Planning Application 33 Chichester Road Bognor Regis POP21 2XH Ref: BR/249/13

We enclose our objections to the application for change of use and should be grateful if you would carefully consider the points we have raised when formulating your recommendations.

OBJECTION TO PROPOSED CHANGE OF USE ON THE FOLLOWING GROUNDS:

Site Plan

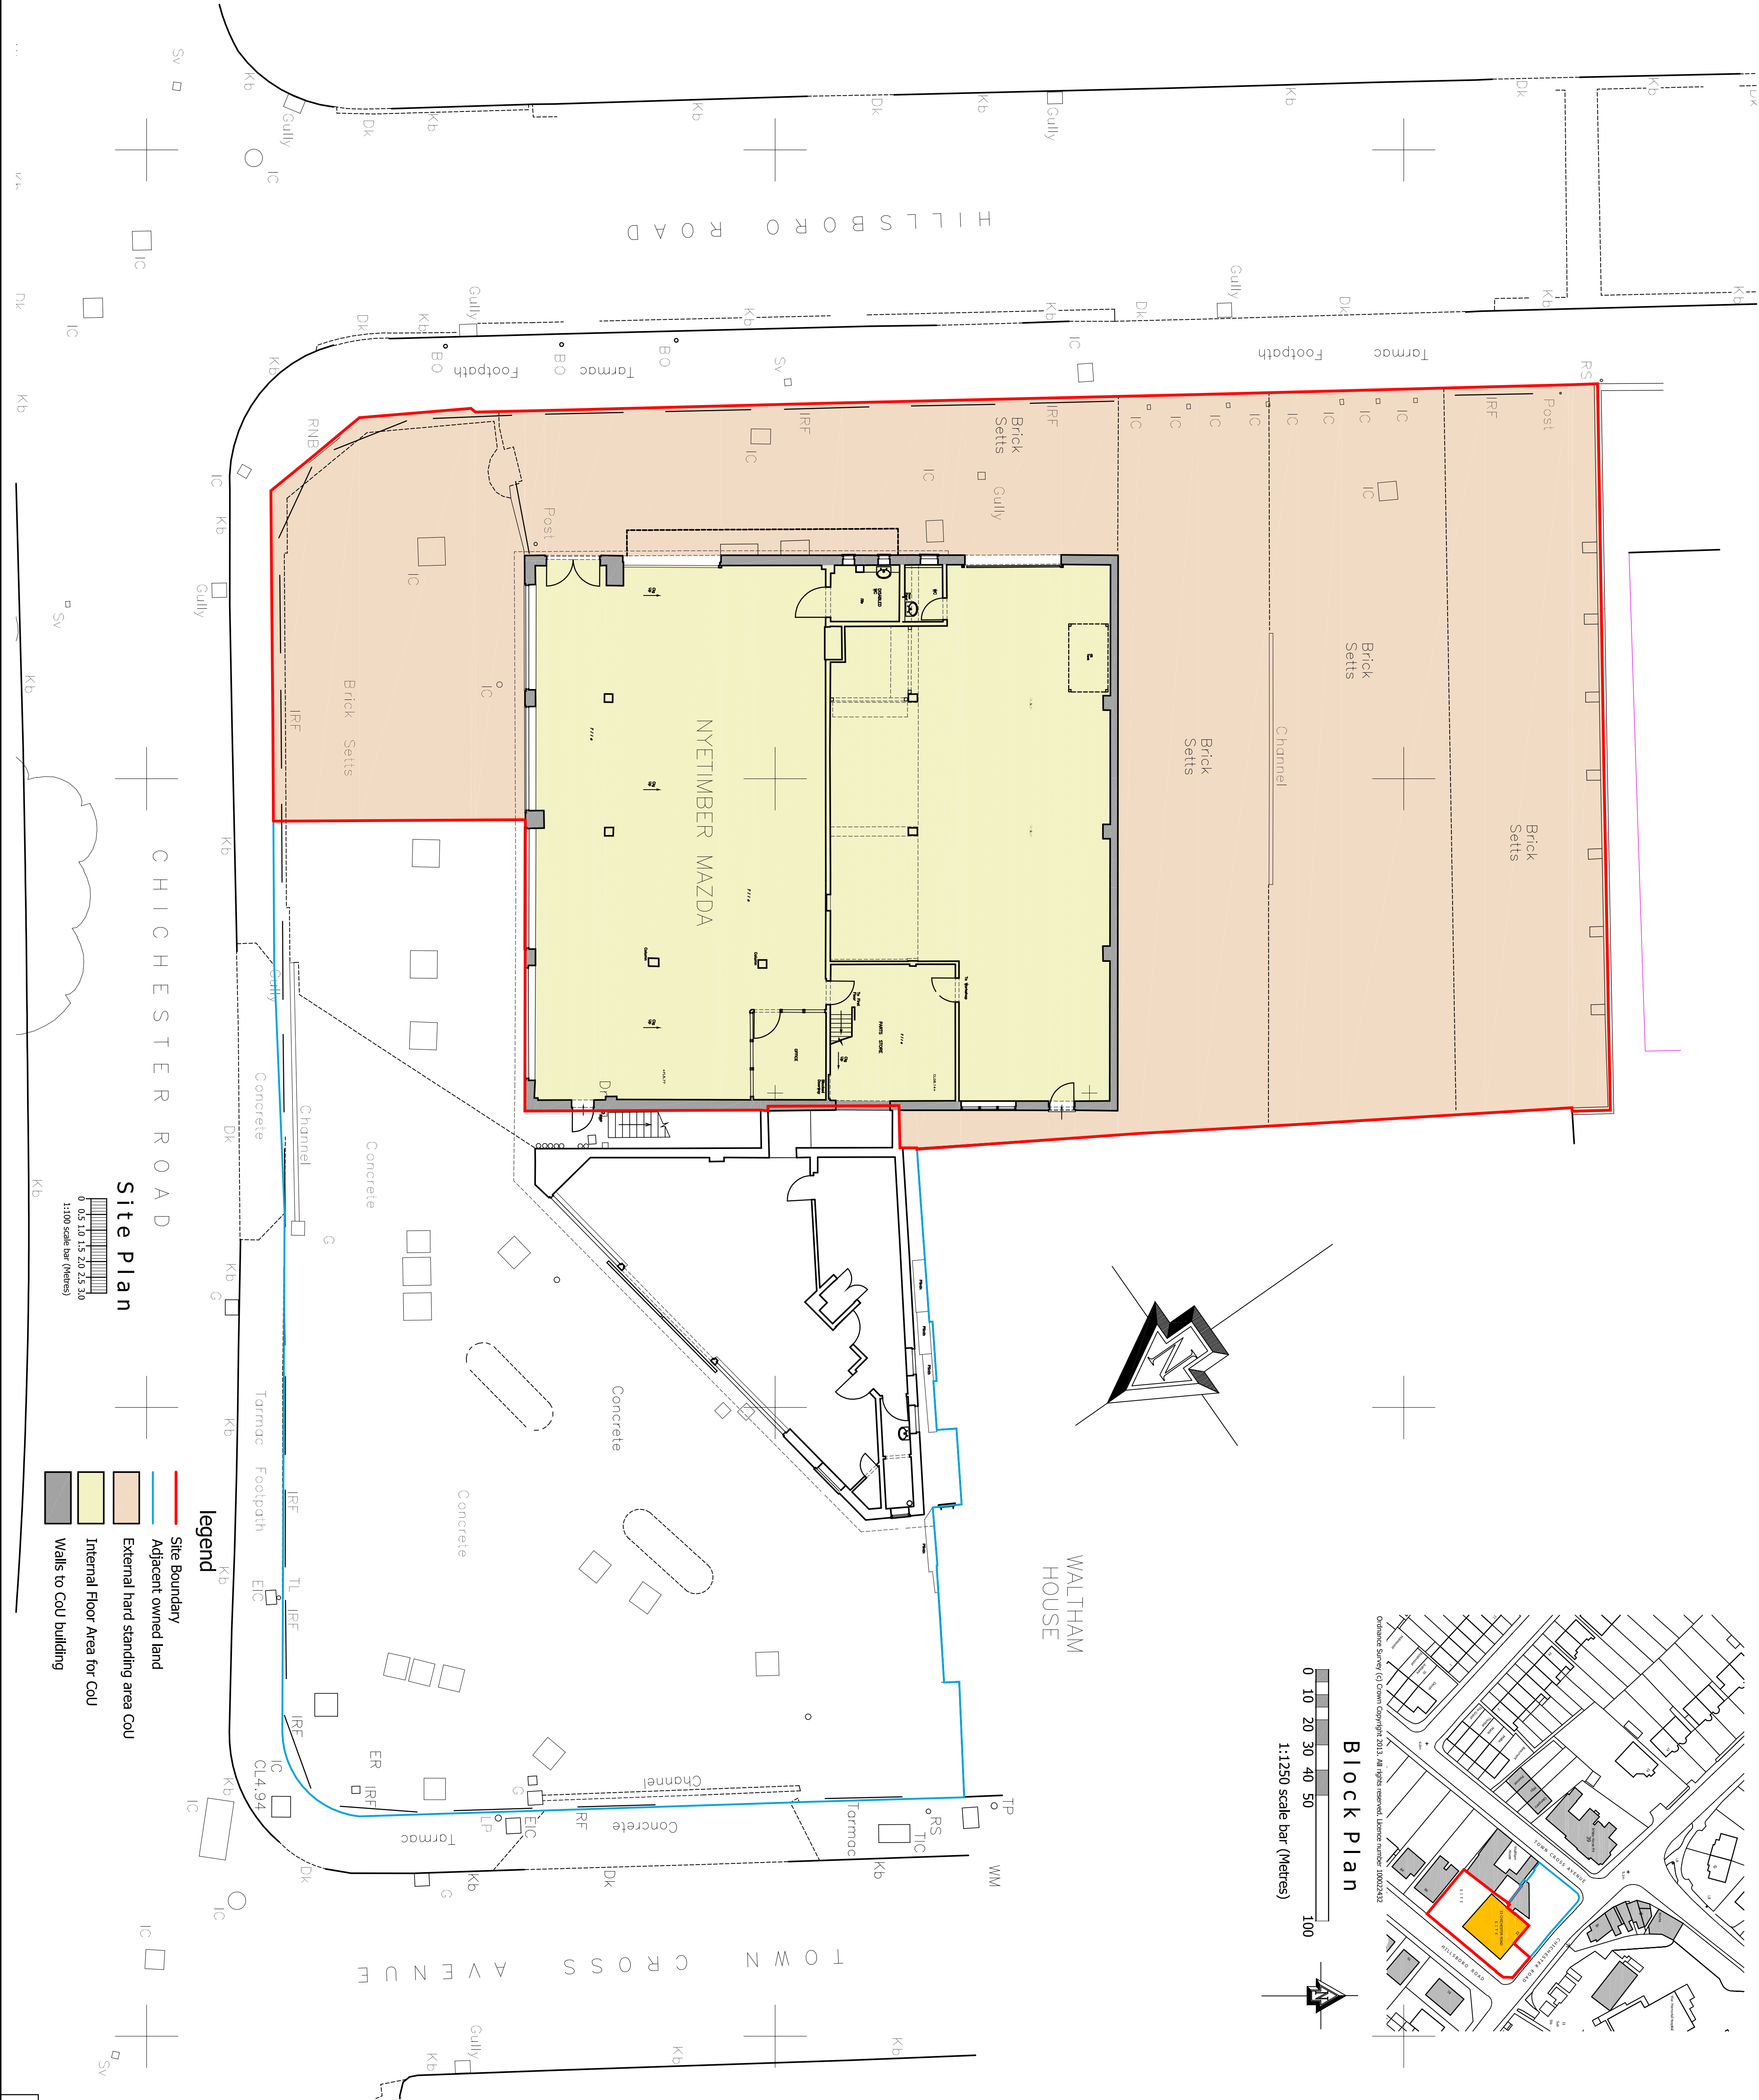
Car park restricted in size. Site tapers giving maximum space lengths of 4.6 metres with central aisle of 5.7 metres at the rear and 5.4 metres at the front. Spaces on one side further restricted by projecting brick piers giving effective bay length of 4.2 metres. This would effectively reduce the central aisle to between 5.3 and 5 metres in width. The recommended aisle width for the class of use considered is 6 metres.

The provision quoted is for 18 spaces, which may be further reduced by the inclusion of secure cycle parking for staff and waste/recycling storage. Planning guidance suggests one space per 14 square metres of floor space. This would require 22 spaces to be provided for the proposed use.

The brick boundary wall between the car park and the residential property at 86 Hillsboro Road (circa 2 metres in height) would be vulnerable to damage and possible collapse as the result of vehicle impact from attempts to manoeuvre in undersized parking provision. A bedroom window is situated within 900 mm of the back of this wall.
